Recommendation Report for Planning Permission for Works or Extension to a Dwelling

REF NO: R/37/22/HH

LOCATION: 71 Old Manor Road  
Rustington  
BN16 3QL

PROPOSAL: Single storey rear extension.

ARW Design	DRAWING TITLE: PROPOSED ELEVATIONS PROJECT: SINGLE STOREY REAR EXTENSION		LOCATION: 71, OLD MANOR ROAD, RUSTINGTON CLIENT: L. LEWIS		SCALE: AS NOTED @ paper size A3 DATE: FEB 2022		DRAWING NO: 6046/2
					DRAWN: ARW REVISION:

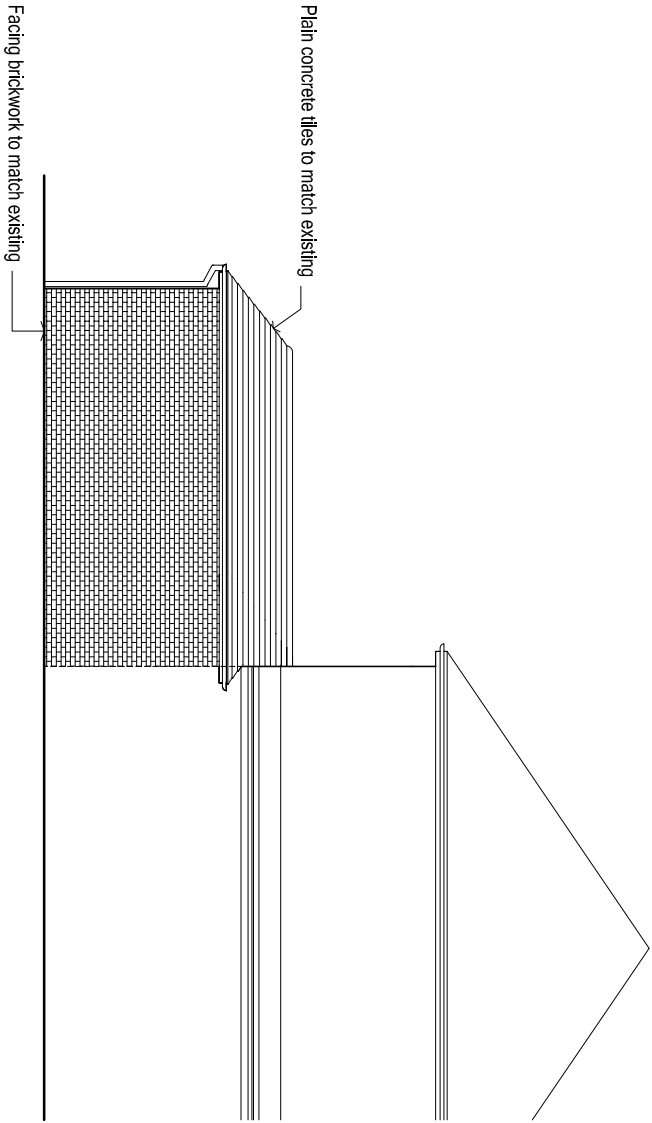
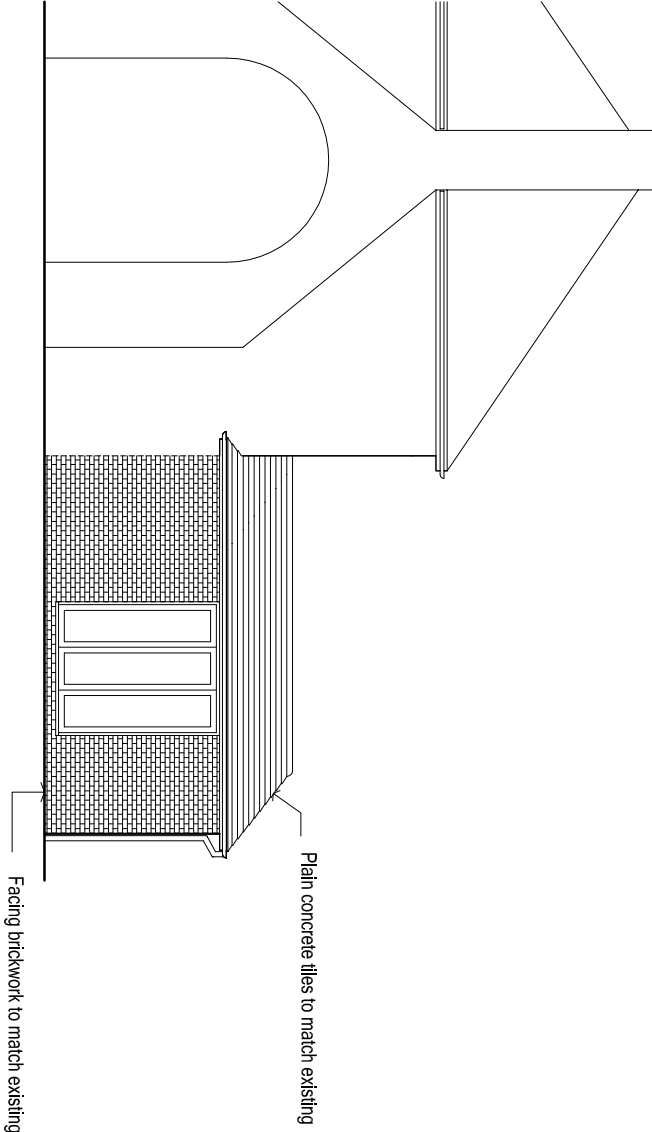
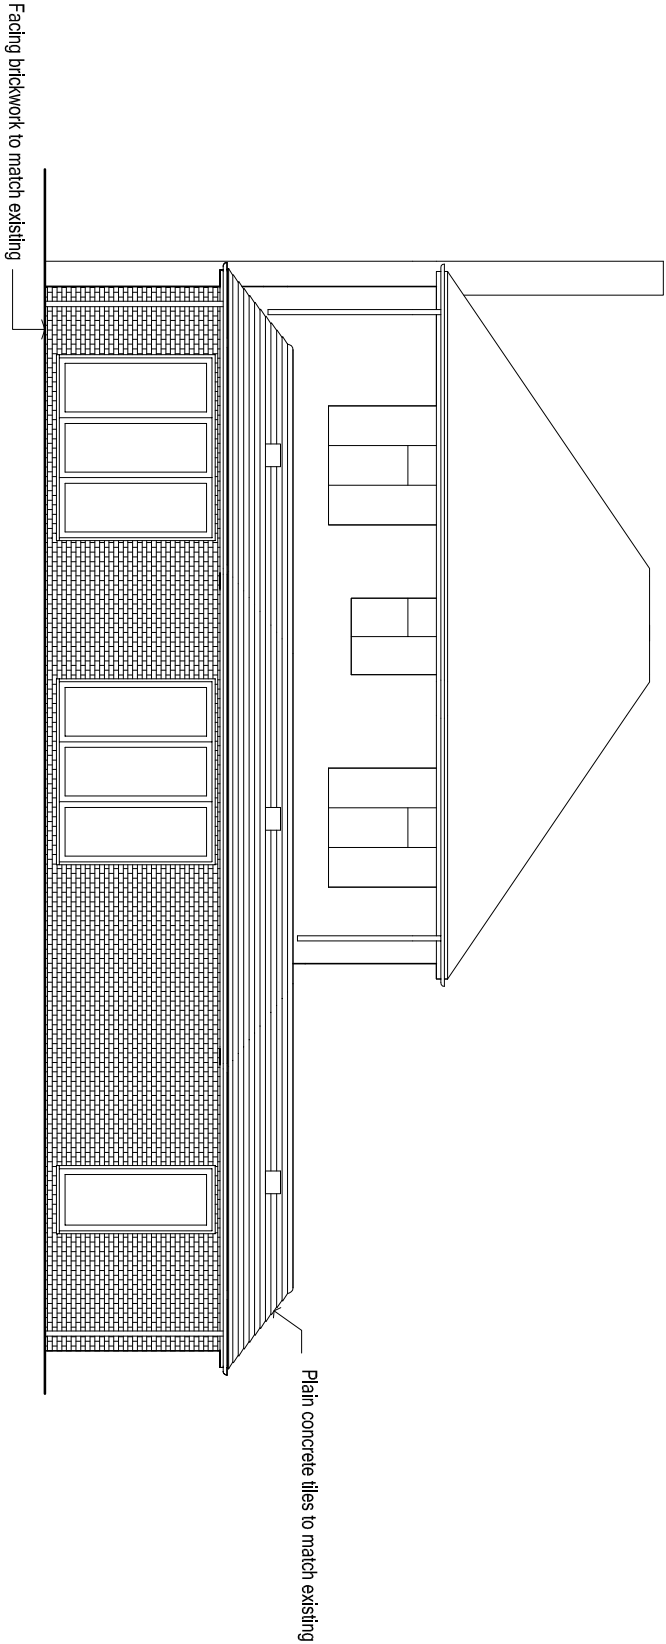
This application seeks an extension across the rear of the dwelling and its attached garage. The rear extension extends approx. 14m across the rear of the dwelling, approx. 3.2m in height and projects approx. 5m to the rear. The proposed extension has been appropriately designed to include a partially pitched roof

The amount of space provided by the extension is proportional to the host dwelling and the plot on which it sits. The bricks and plain concrete tiles used in this proposal match the existing and achieve acceptable visual integration. The overall height of the development is significantly lower than the two-storey host dwelling and it is to be located so as not to impact the primary elevation of the dwelling. The use of appropriate scaling also contributes to the proposal's complimentary visual integration and it will comply with Policy D DM3 (a) (b) as it is subservient to the existing dwelling.

In terms of overlooking, all proposed fenestration faces towards the east, towards the rear garden or south, where there is a separation gap of 5m until the shared boundary. All proposed windows will be located at ground floor level where it is generally accepted that overlooking of neighbouring properties

ARW Design	DRAWING TITLE: GROUND FLOOR PLANS		LOCATION: 71, OLD MANOR ROAD, RUSTINGTON	SCALE: AS NOTED @ paper size A3	DRAWING NO: 6046/3		
	PROJECT: SINGLE STOREY REAR EXTENSION					DATE: FEB 2022	DRAWN: ARW

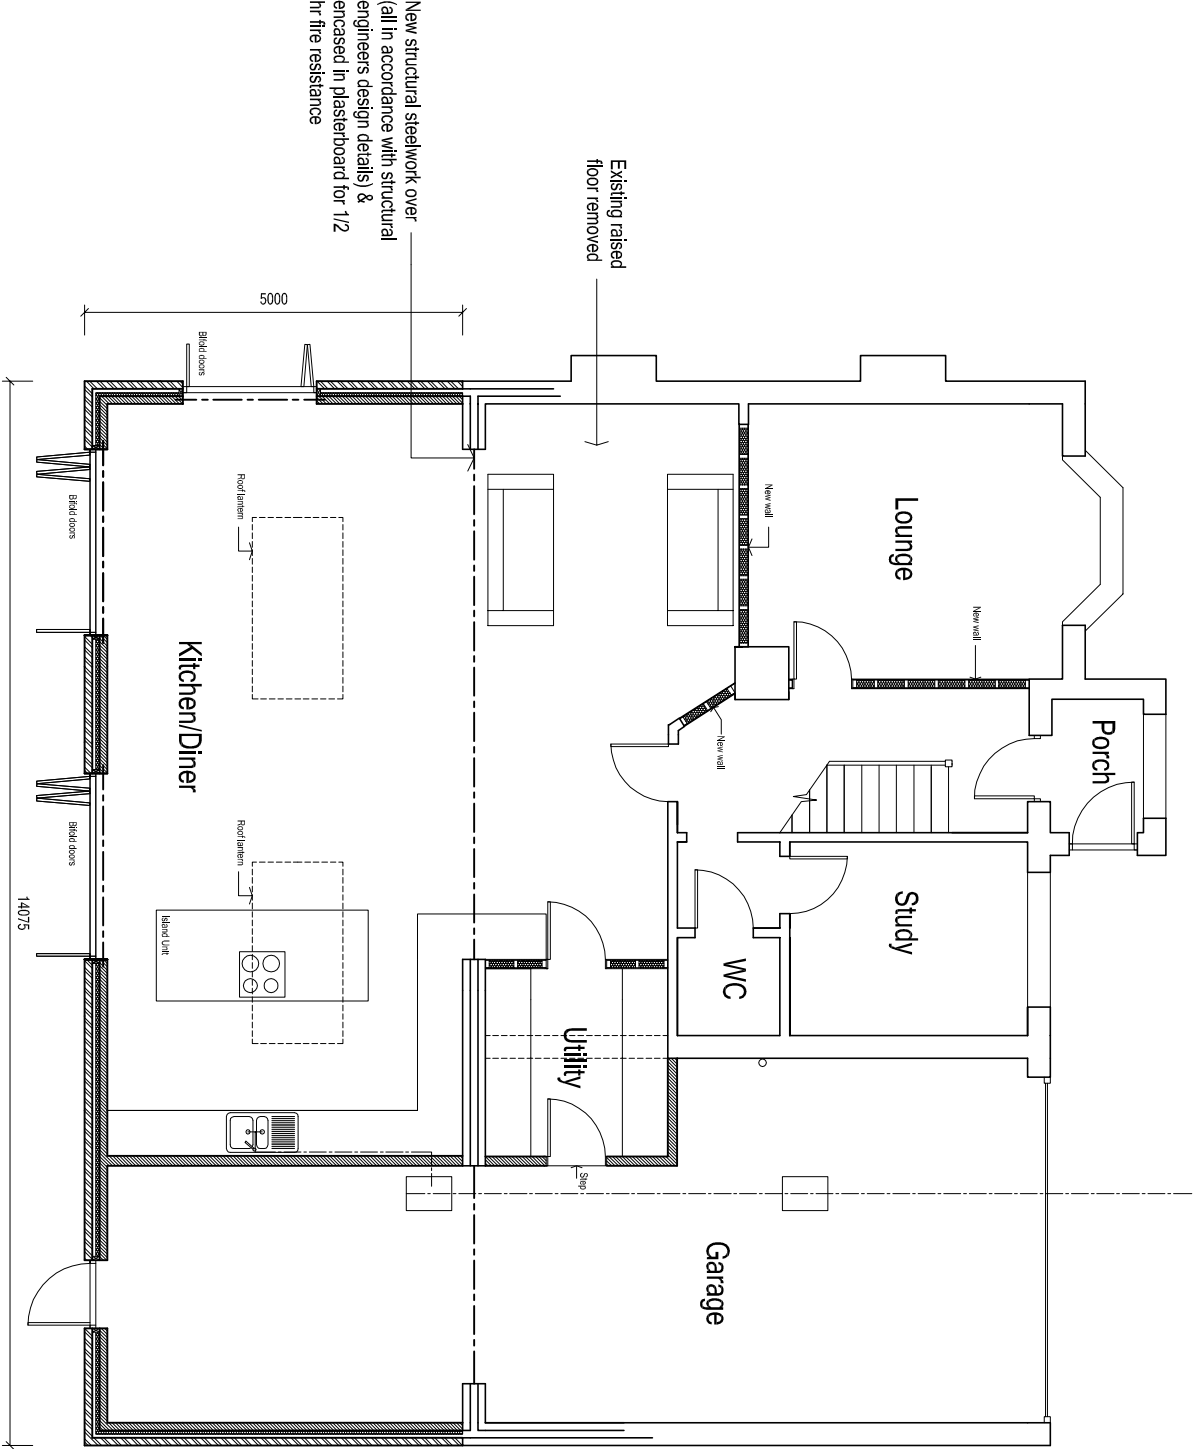
The application description makes reference to a side extension to the garage, however according to plans no side extension is proposed.
